File: SF21/78458
Job ID: DOC21/549817

RE: Request for Advice – Atlassian Office and Hotel Development (SSD-10405) Central Precinct – Response to Submissions

Frank Howarth AM PSM
Chair, Heritage Council of NSW

14 July 2021

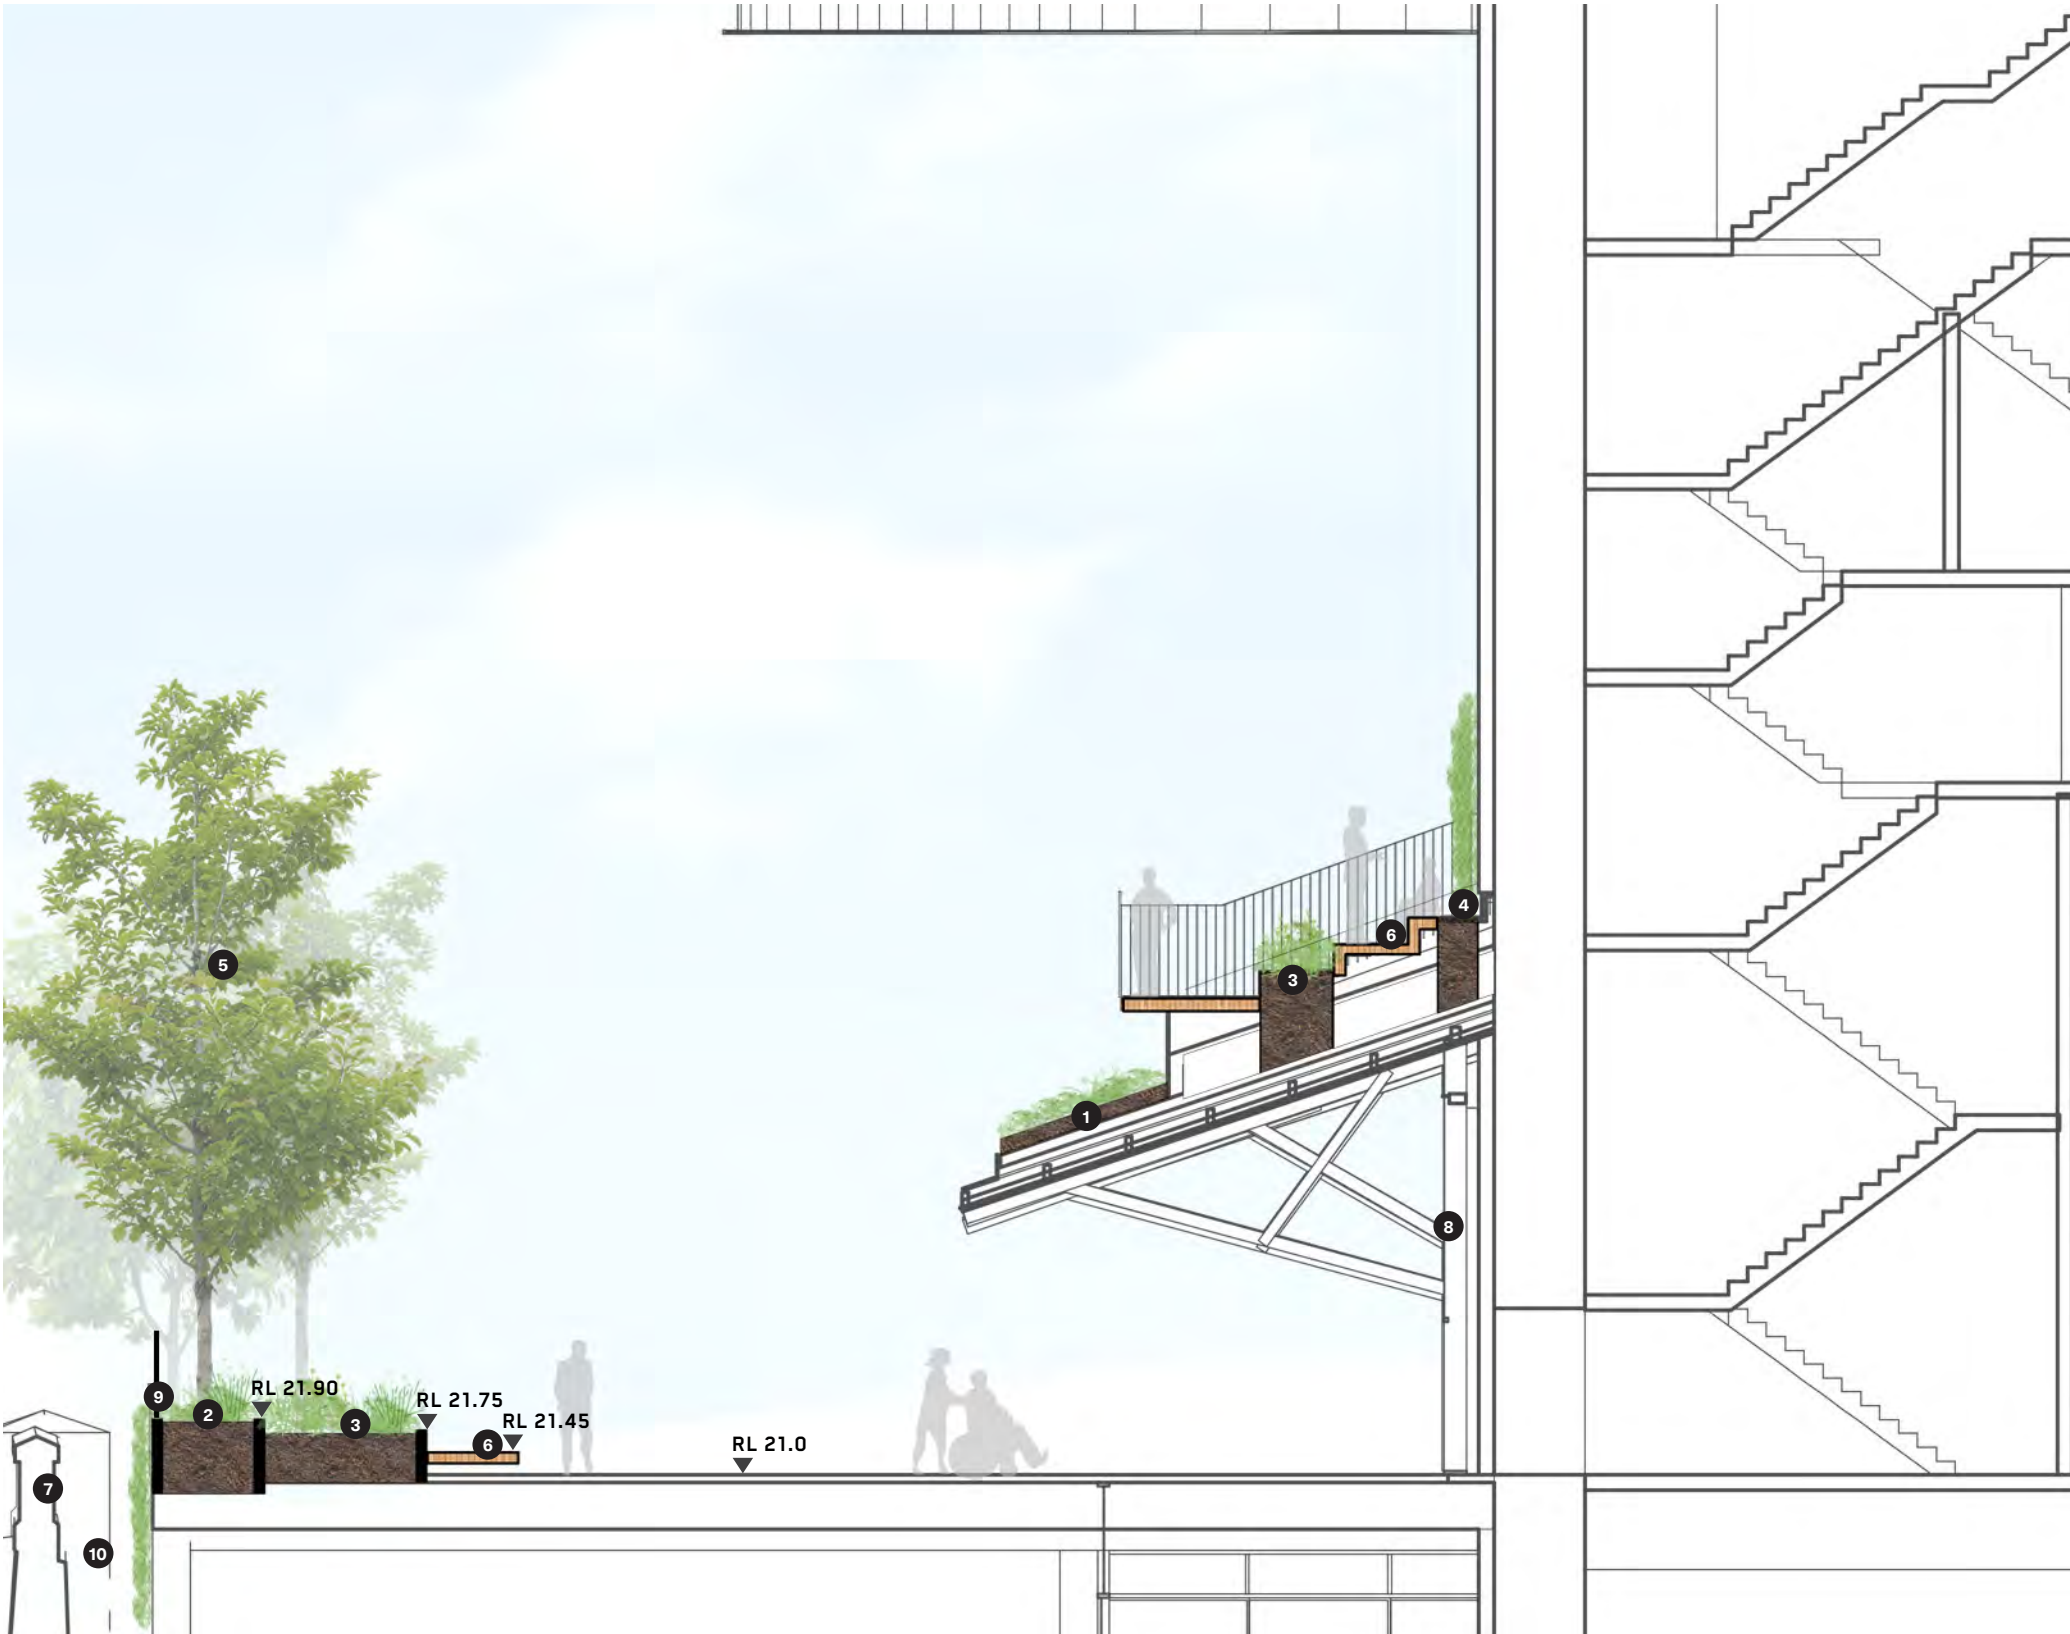
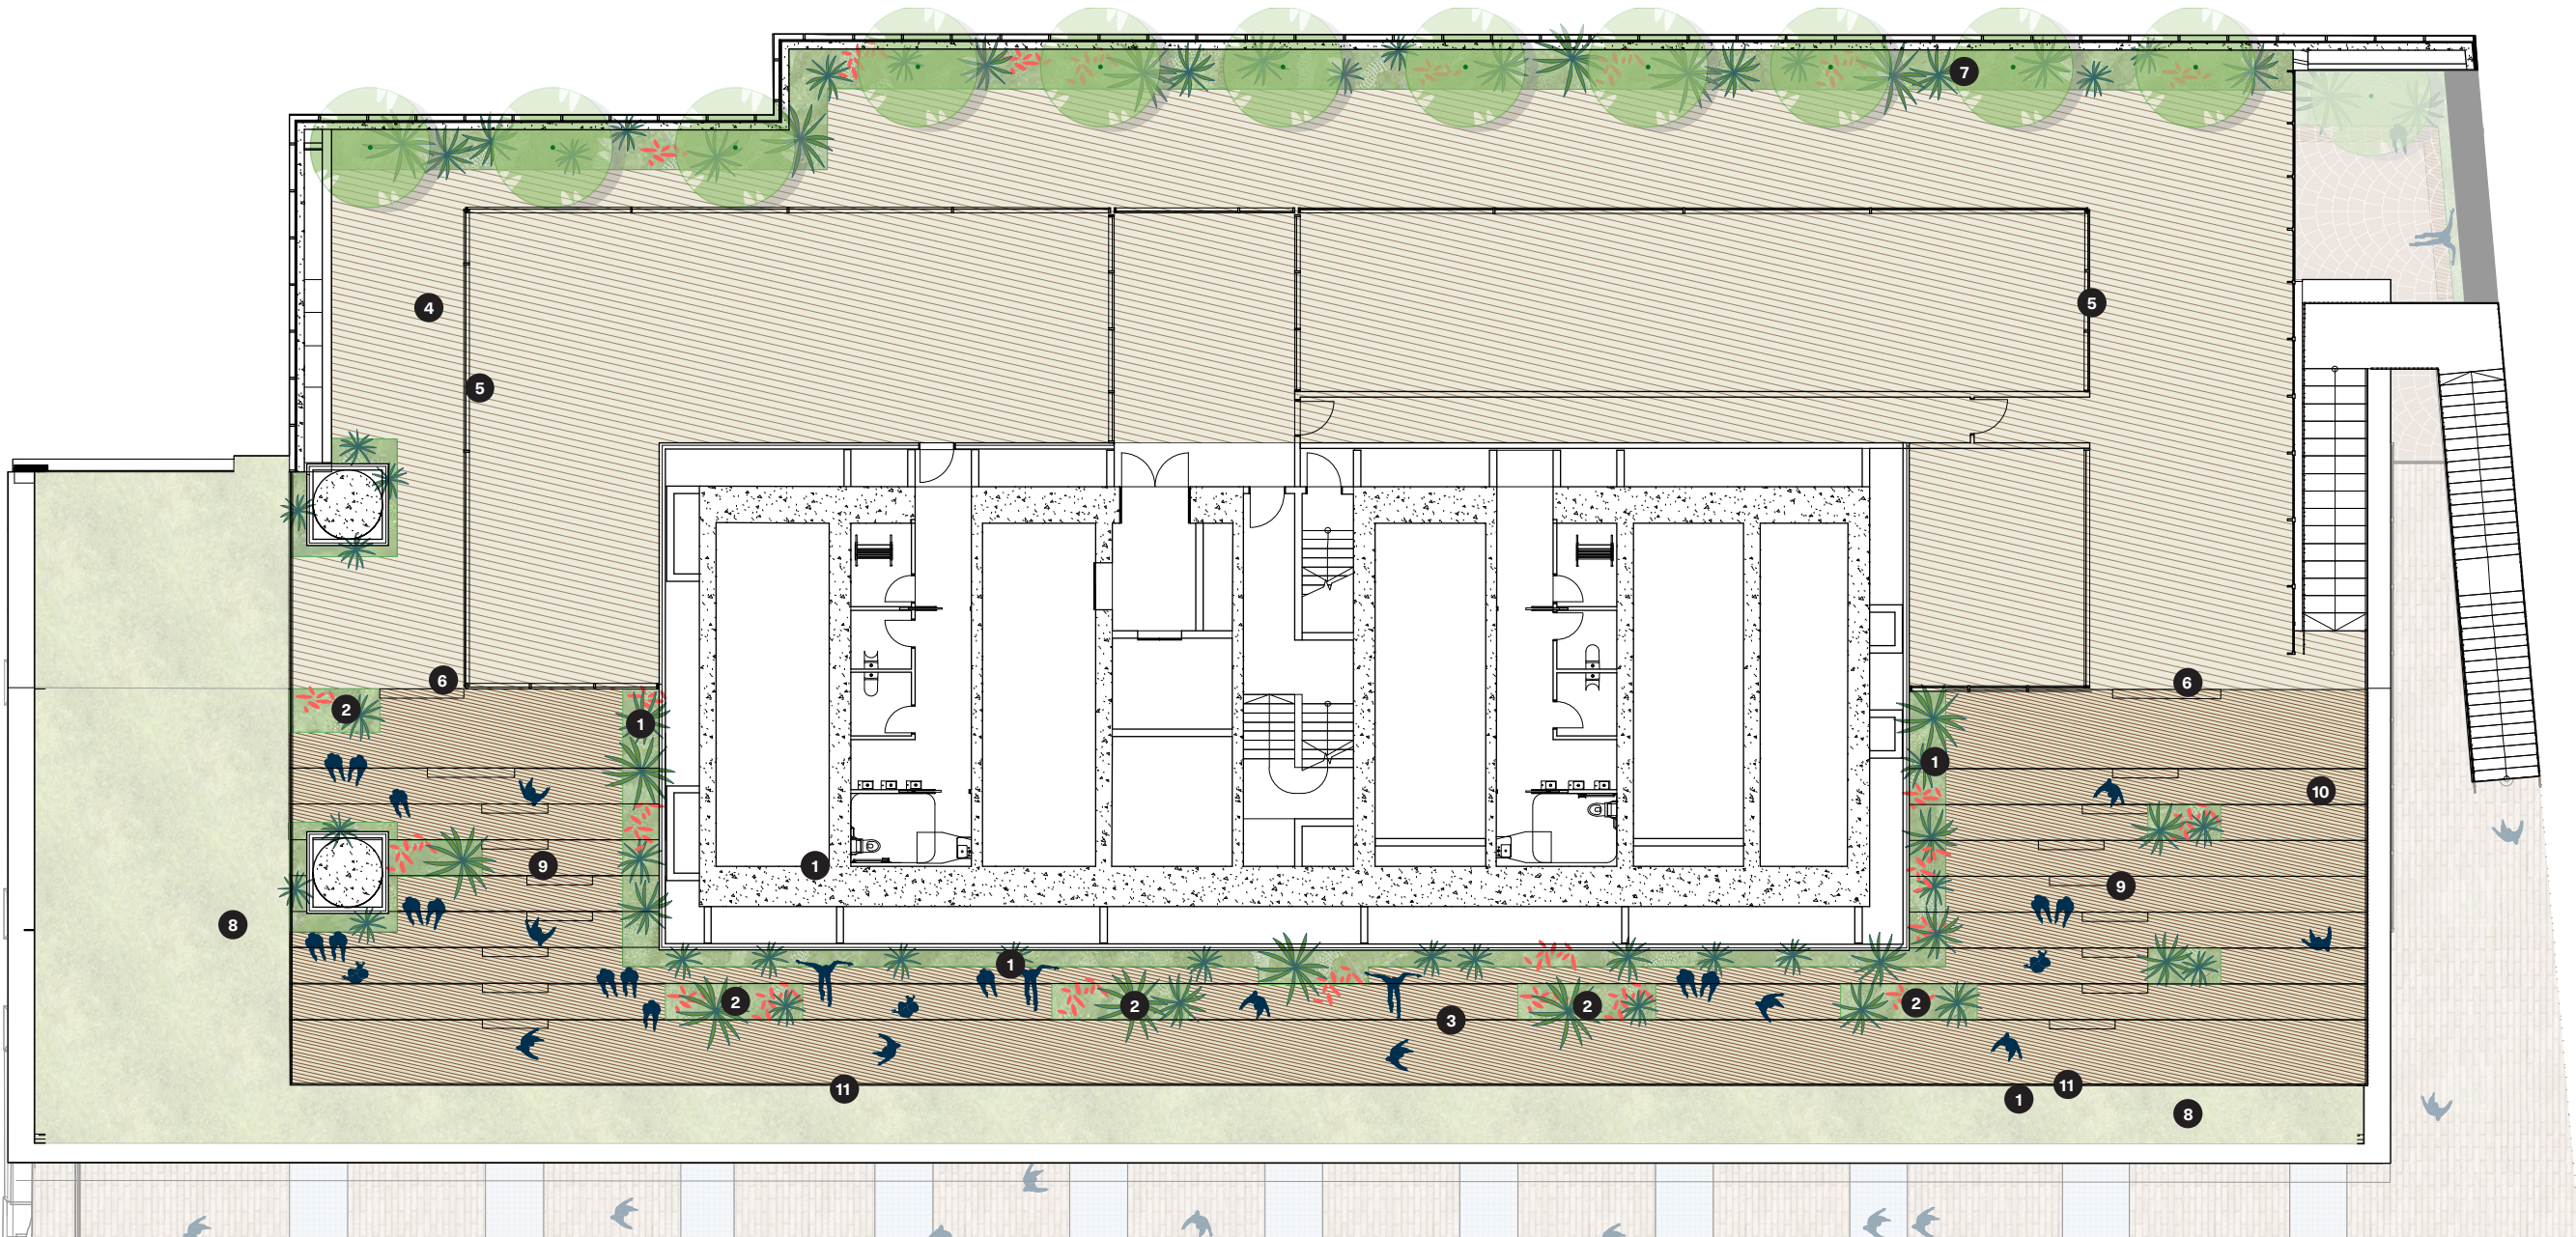
- Again, we request that the legibility of the adapted former Inwards Parcel Shed be emphasised, further to our previous comments around the insertion and scale of the new tower and cumulative neighbouring developments. This includes the Heritage Council request to remove or significantly re-scale the proposed green roof, sought by Atlassian as part of the proposed adaptation of the former Inwards Parcels Shed. This was a significant element of previous Heritage Council submissions and sought to achieve a better reflection of the original, unadorned industrial character of the shed post the insertion of a multistorey tower through its innards. It is noted that the green roof component is still proposed as part of the works but with limited additional content to demonstrate how heritage impacts have been minimised.

Recommendation: The green roof component of the works to be substantially modified to minimise impacts to the industrial character of the site, its setting and the shed. This is to be undertaken to the satisfaction of the Heritage Council.

| Drawn by: JLF               | Figure: 20 |

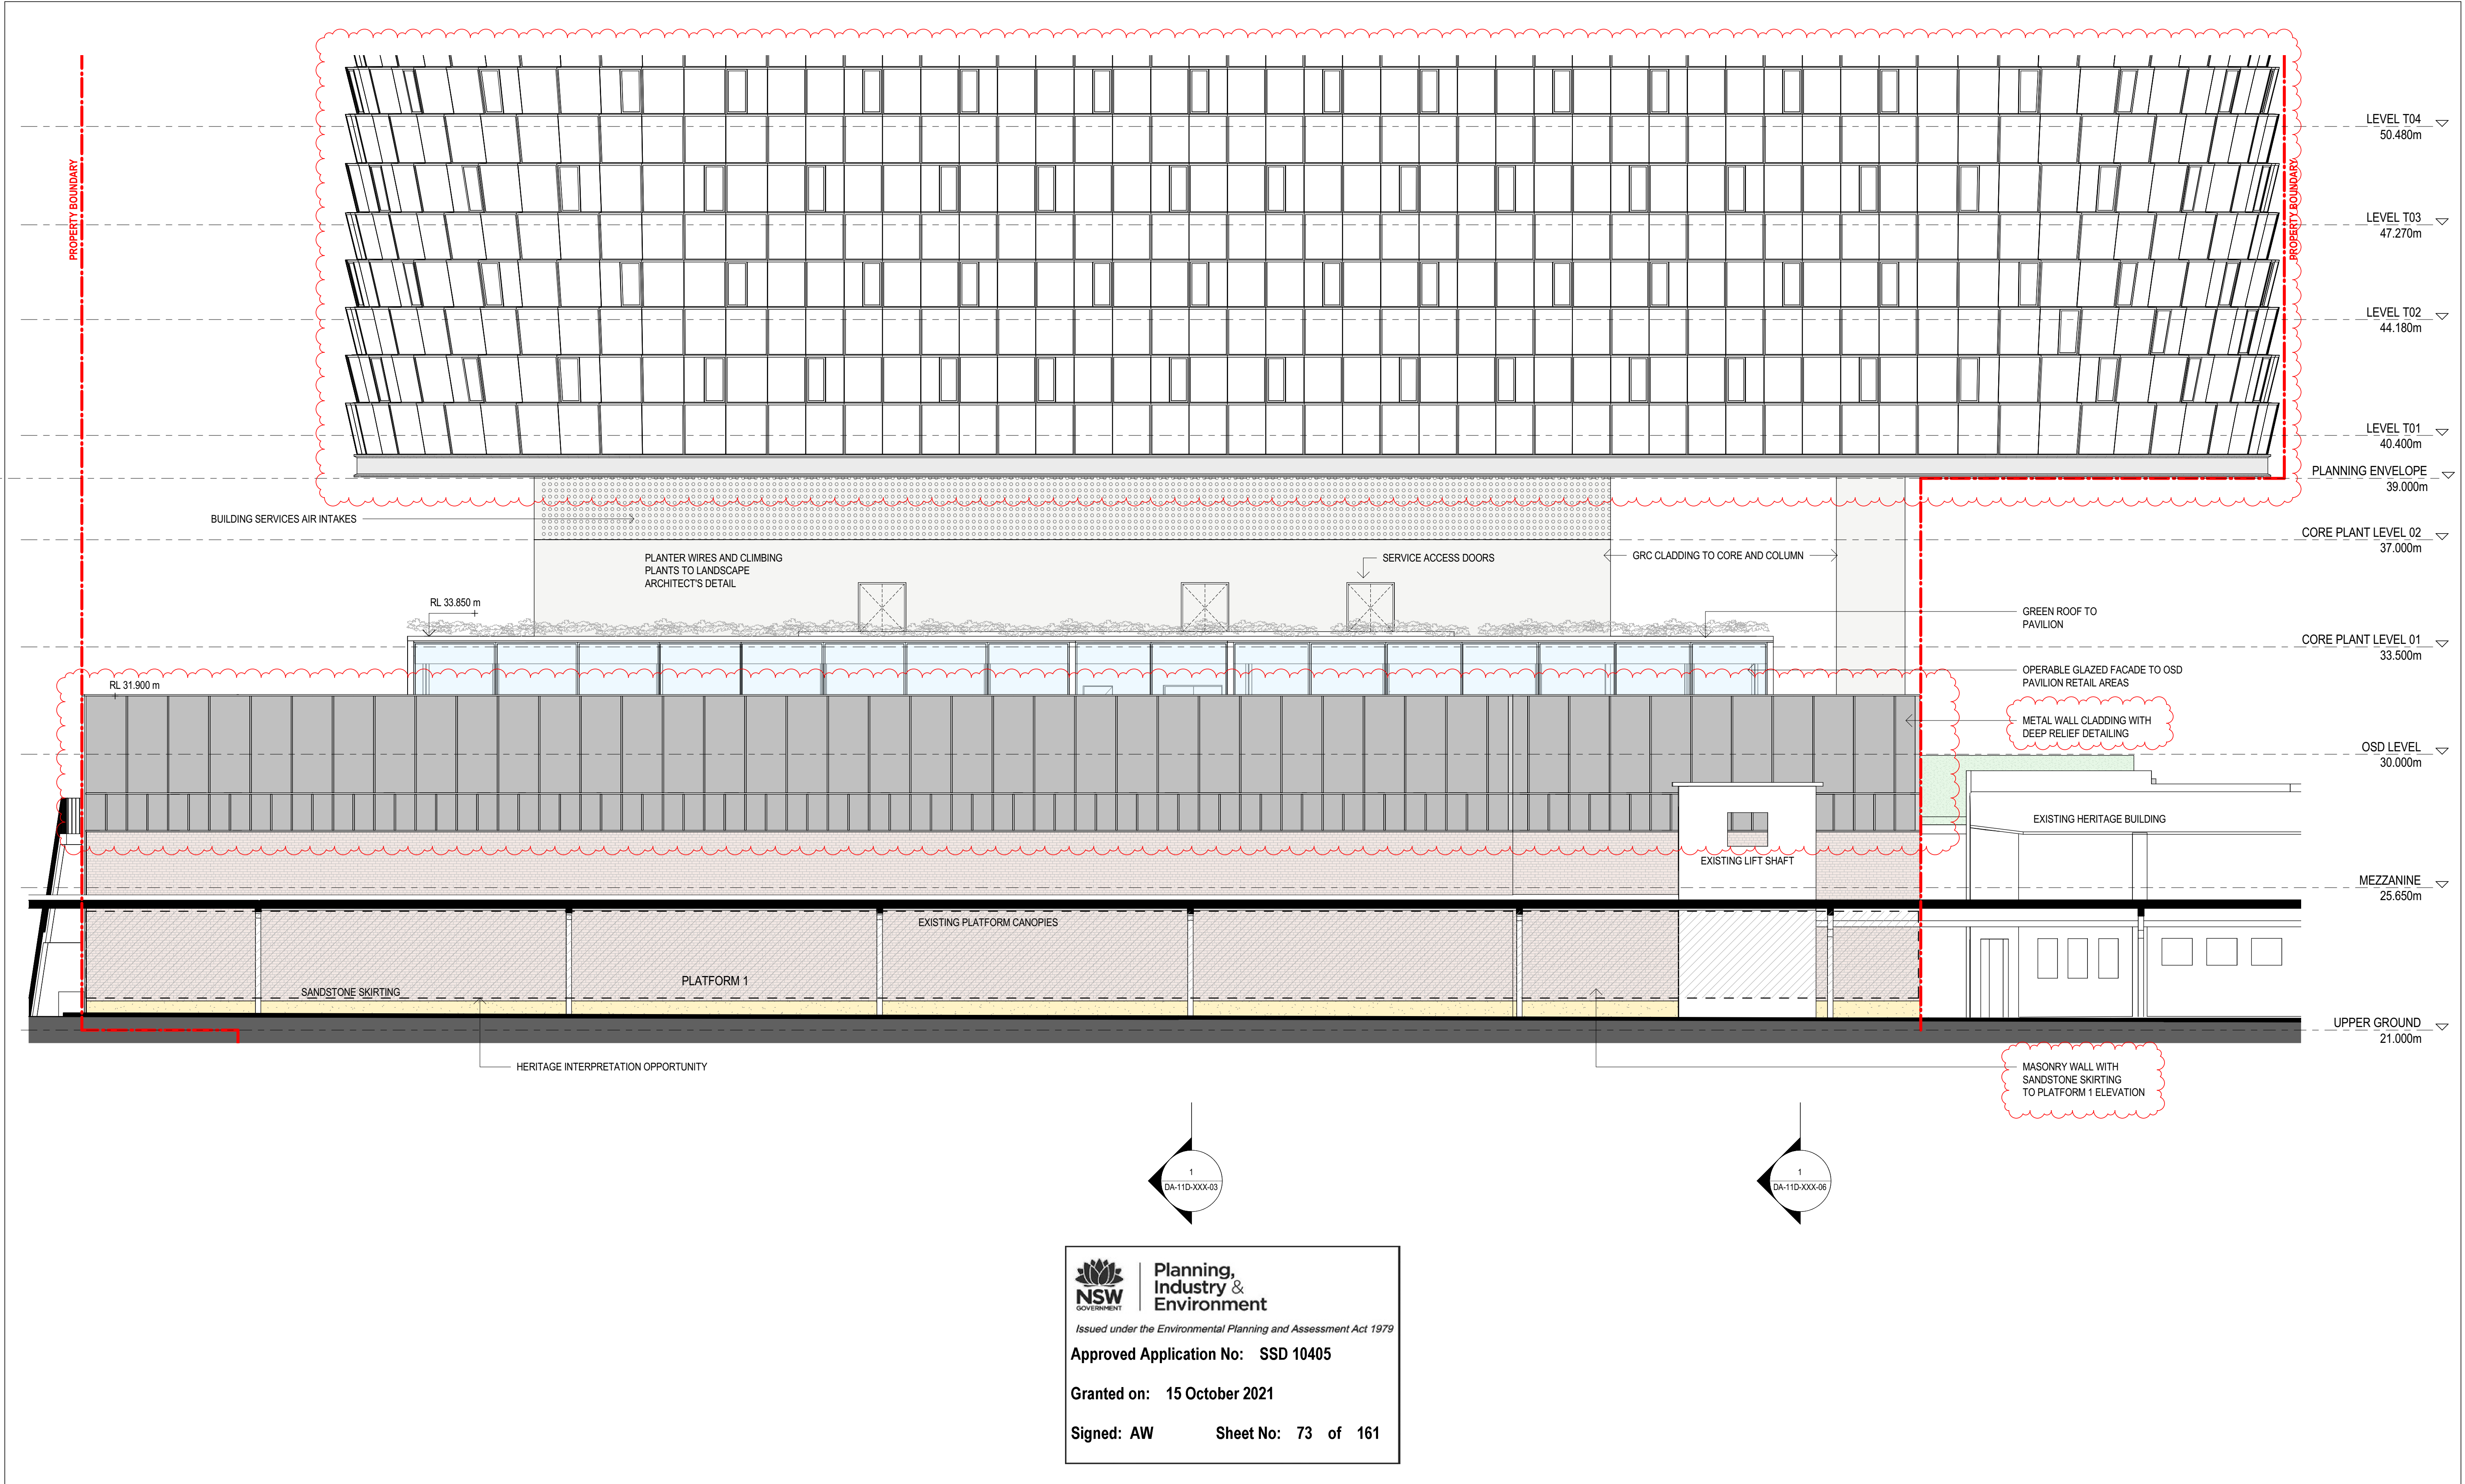
- The former Inwards Parcels Shed is historically important as an integral part of the SHR listed Central Railway Station and contributed to the role of the railway transport system in the delivery of regional mail. As stated above, the proposed works include demolition and a partial rebuild of the Shed which will have obvious impacts to fabric and setting. We previously requested a reduction to the extent of demolition and removal of fabric as much as possible to minimise impact to significant/original fabric.

- It is not clearly demonstrated from the additional information provided how the reuse of the demolished fabric will be incorporated and used appropriately. It is unclear how it will be determined what significant elements will and will not be salvaged and the reason for their inclusion/exclusion. Elements such as the brick chimneys and sandstone plinths of the shed provide evidence of the former use of the area and association with the former Inward's Parcel Shed and its historic function. As noted previously, these elements provide visual clues as to the former use and function of the place and should be meaningfully used as part of the adaptation and interpretation of the building..

Recommendation: Further detail and designs are required to understand what elements will and won't be salvaged, and how this is determined. Then how they will be reused. This should be undertaken in consultation with, and to the satisfaction of the Heritage Council or its delegate.
